**ENVIRONMENTAL ASSESSMENT EXHIBITION OF MAJOR PROJECT 09_0166-
ALTITUDE ASPIRE AT FRASER DRIVE, TERRANORA**

DETAILED COMMENTS

Environmental Assessment: Altitude Aspire at Fraser Drive, Terranora

ROAD LAYOUT

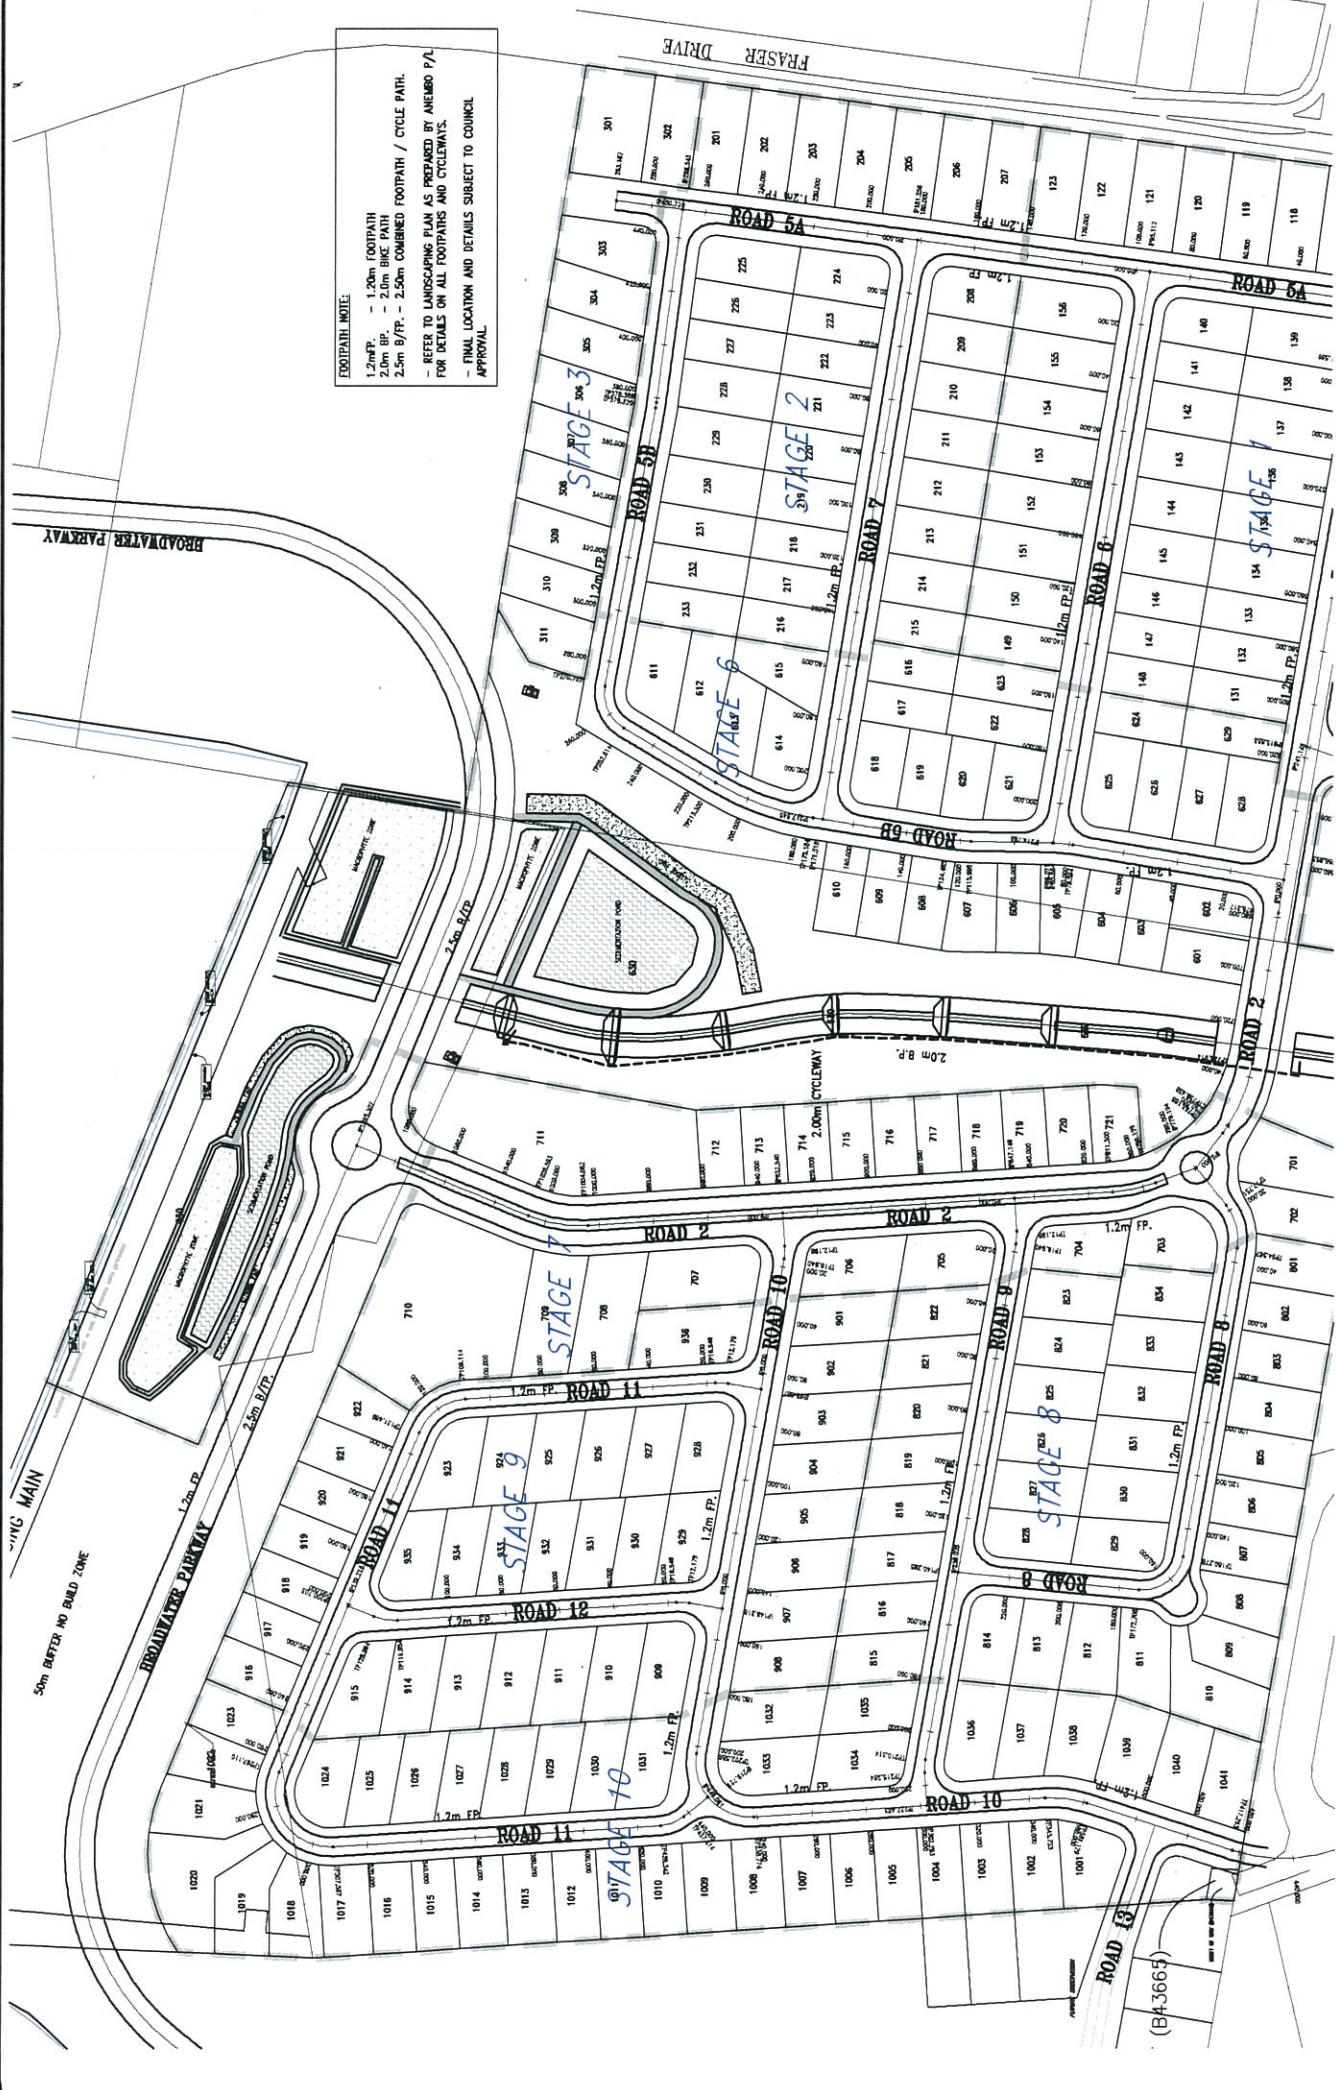
- The proposal has limited direct access to Fraser Drive for pedestrians and cyclists. It is requested that a shared mid block access point be considered for pedestrians and cyclists.
